# HyNet Carbon Dioxide Pipeline

Written Response Statement on behalf of Peel  
NRE

Planning Inspectorate Reference: EN070007

18 July 2023 (Deadline 6)

DRAWING TITLE  
**Ince - Above Ground Installation (AGI) Drainage Layout**

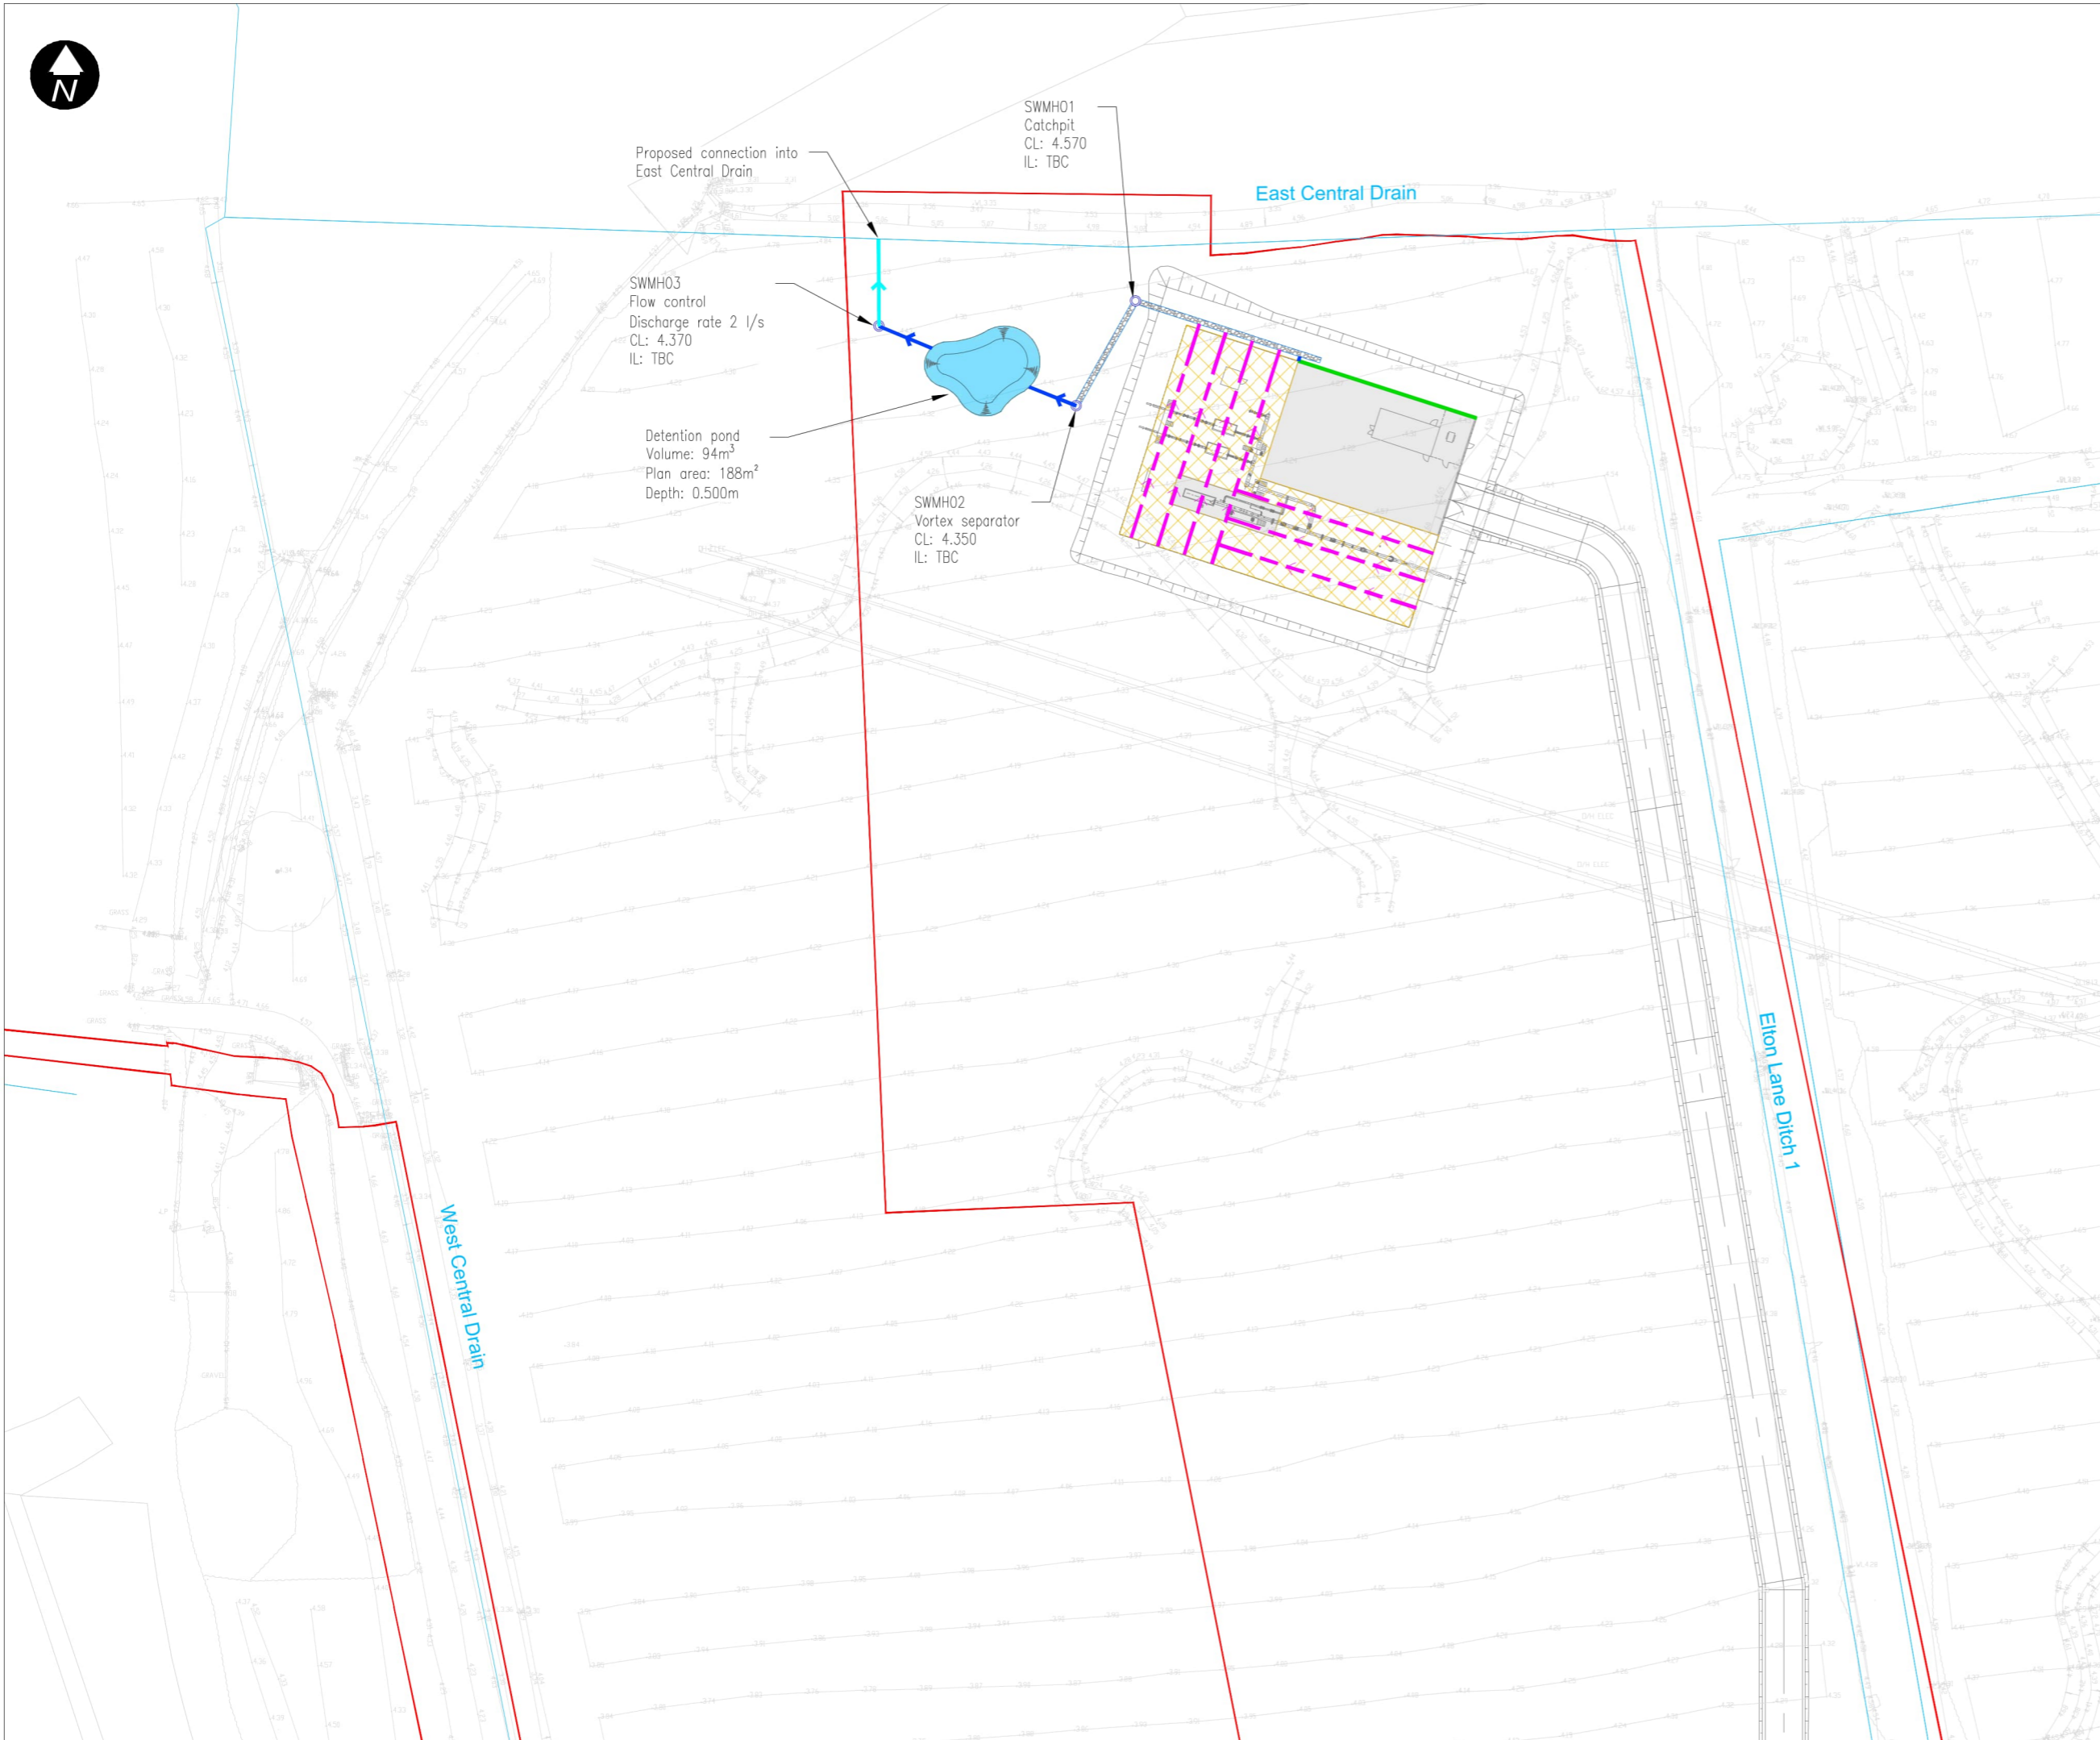
- 2.4 The Ince AGI Landscape Layout (ref. D.2.14-LAY-Sheet 2 Rev B) identifies the location for landscaping/ecological mitigation and a drainage detention pond. It is acknowledged that an updated drainage design has been submitted at Deadline 5 (ref. D.6.5.13 Surface Water Drainage Strategy Rev C), with updated Landscape Layout and AGI Layout to be provided later in the Examination. Whilst this resolves number of the previous issues, the updated location of such features still has the possibility to constrain future planned development across the Affected Land. Peel NRE accordingly objects to the current proposed layout of the Ince AGI.

- 2.18 With relevance to the Ince AGI, no Environmental Mitigation Areas are defined on the Works Plans (D.2.4-WP-Sheet 1 Rev G).
- 2.19 The updated Surface Water Drainage Strategy (Rev C) shows a change to the proposed drainage outfall from East Central Drain (to the north) to Elton Ditch 1 (to the east) of the Ince AGI. Within the previous arrangement, ecological mitigation measures were proposed including an area of riparian habitat enhancement along the southern bank of East Central Drain (D.2.14-LAY-Sheet 2 Rev B). It is not clear at this stage whether riparian habitat enhancements are now proposed along Elton Drain 1, at the location of the now proposed outfall. In addition, there will be planting of native triple staggered hedgerow, hedgerow, trees, native shrub planting and species rich grassland around the Ince AGI. The location and extent of such works should be confirmed and discussed with Peel NRE to ensure that these do not prejudice future development ambitions.

- 2.5 Through conversations between Peel NRE and the Applicant, it is understood the layout of the Ince AGI will be updated to addresses Peel NRE's concerns. This is a welcomed proposal. However, until the updated layout plan is formally submitted, and the Applicant obliged to carry out its proposal in accordance with any amended agreed layout, Peel NRE maintains its objection on this basis, although Peel NRE is confident this objection will be resolved with the Applicant (including through further discussions at detailed design).
